Re: Forest Ridge (LPF-22-00006) Final Long Plat Ph 4 – RFI #2

Please find enclosed a final mylar reflecting the comments provided by County departments. Below is a response to each County comment:

OPEN SPACE COMPLIANCE MAP

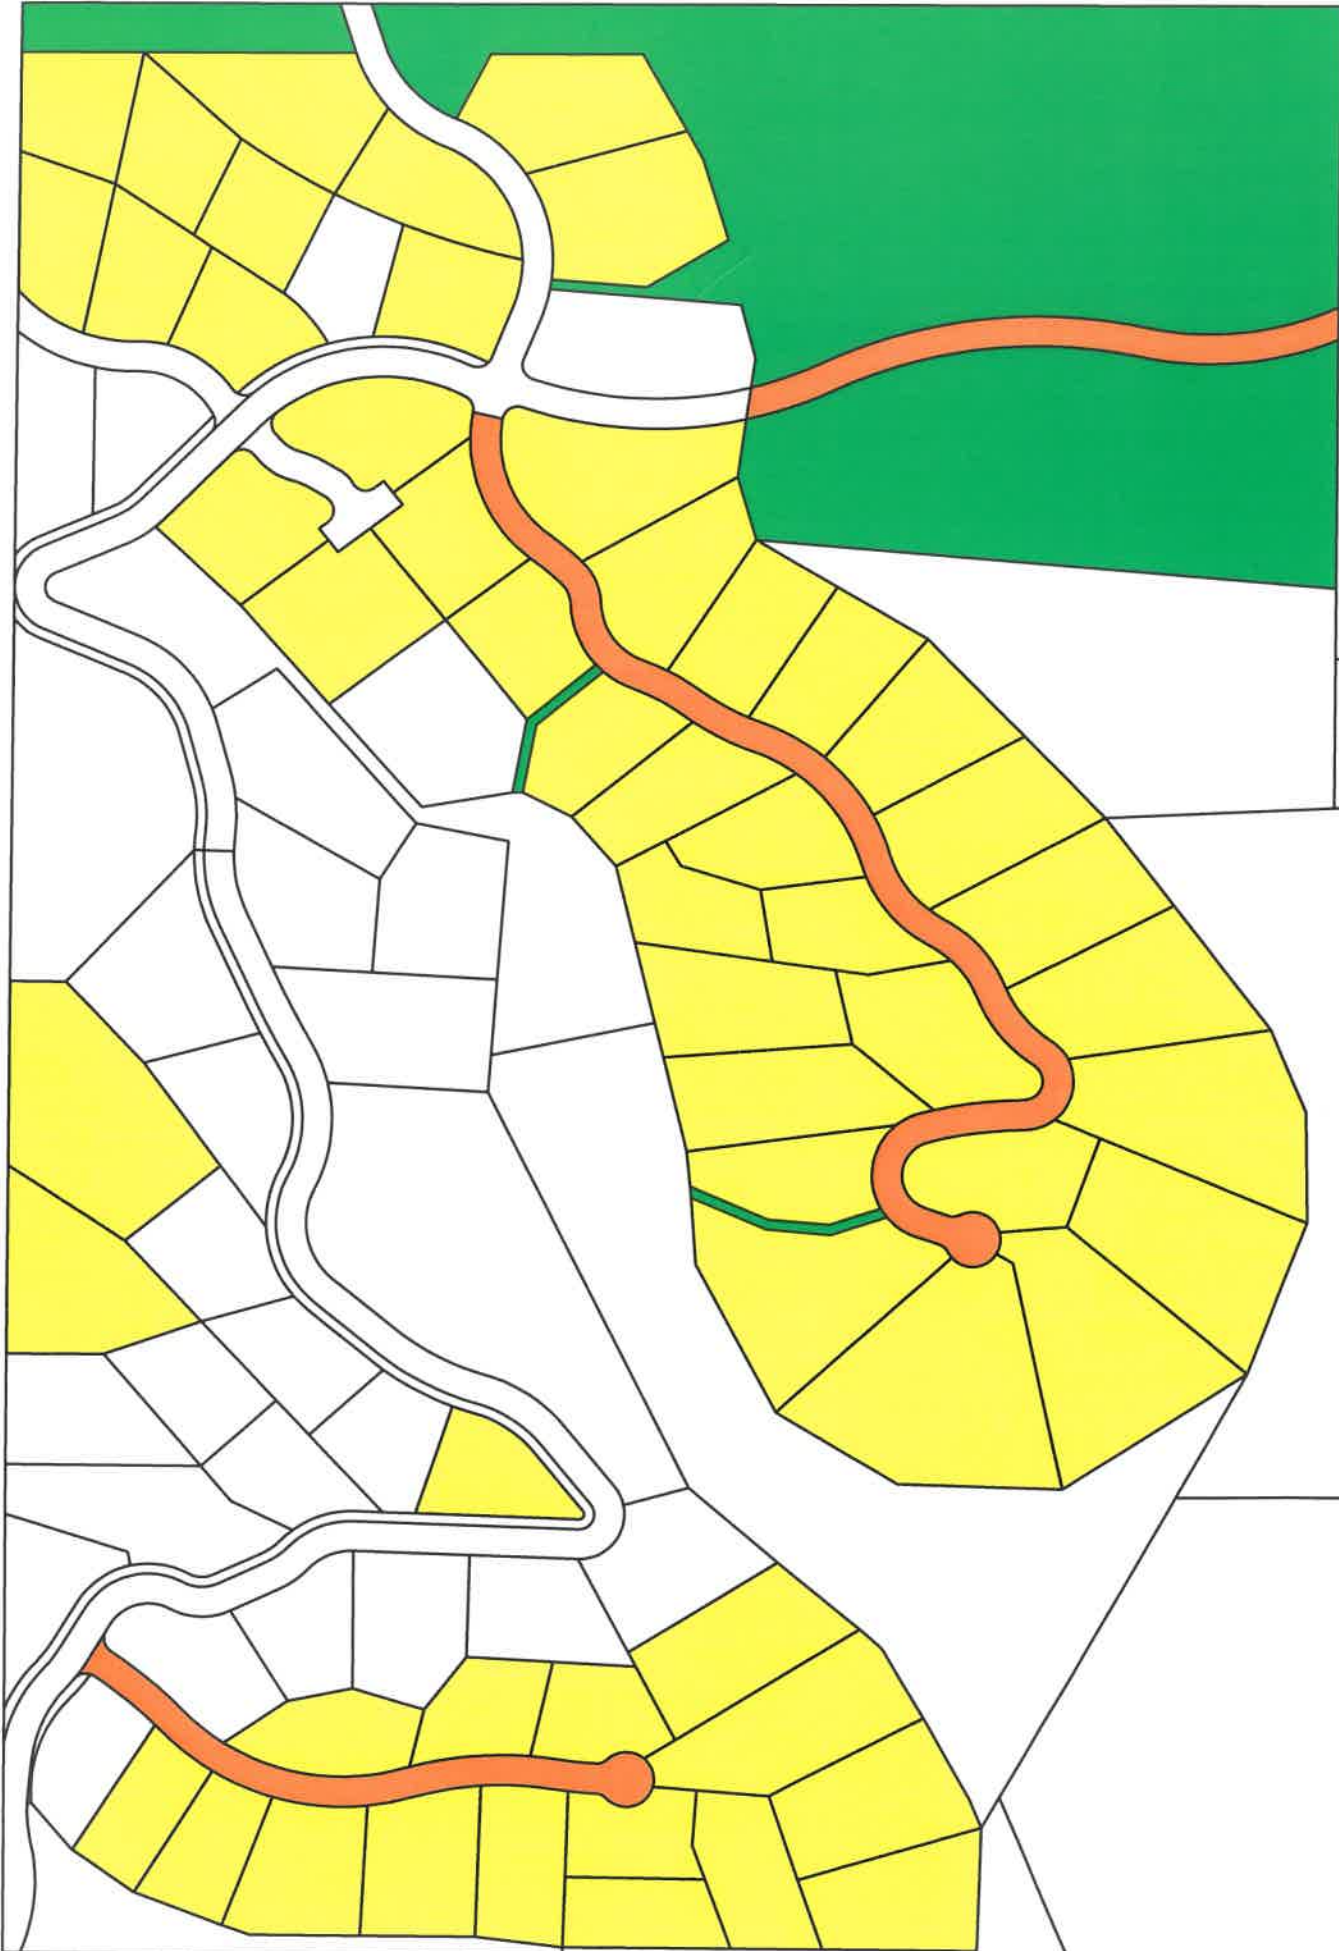
- *Demonstrate and show open space calculations*
 - See enclosed comprehensive open space calculation for all 5 phases of development. Both Encompass Engineering & Surveying and Contour Engineering worked to together to ensure a minimum of 40% of open space is provided while deducting the commercial forest setback area, streams, wetlands, and associated buffers.
- *Provide documentation that an approved water supply can be capable of supplying the required fire flow.*
 - Water design has been approved by WSDOH and bonded with KCPW. Group A water system is currently under construction and proper testing and inspection is being conducted as progress is being made.
- *Open Space Management Plan*
 - See enclosed management plan prepared by a professional biologist.
